**VISUAL SIMULATION JUWI SOLAR**  
JUNE 2018 • CONTACT: MARILYN WAGMAN (720) 636-8268

Fountain, CO

VISUAL SIMULATION JUWI SOLAR

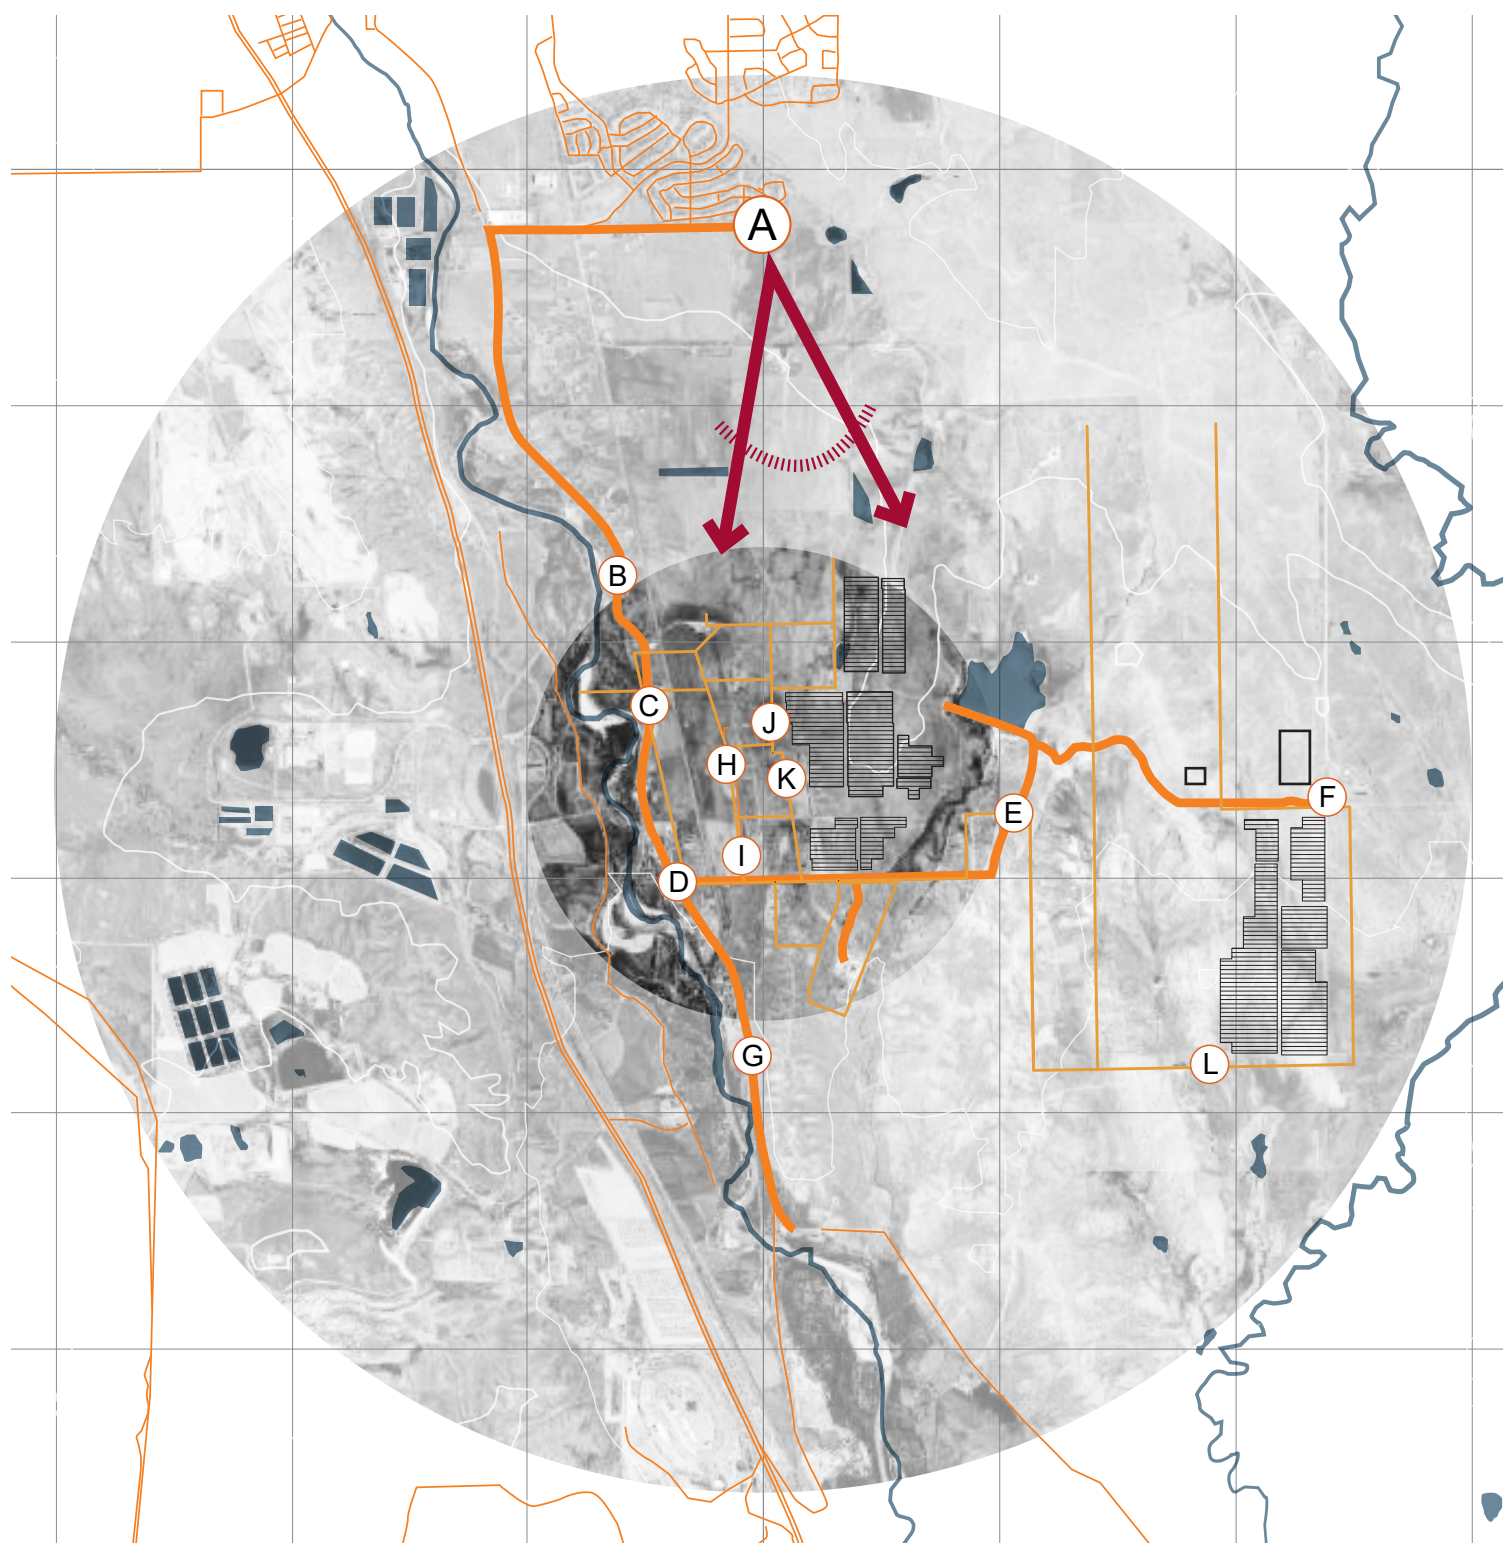
identify the parcel boundaries so that we can verify impacts to adjacent property owners have been minimized

Depending on adjacent property locations -provide more points as indicated by green lines where applicable
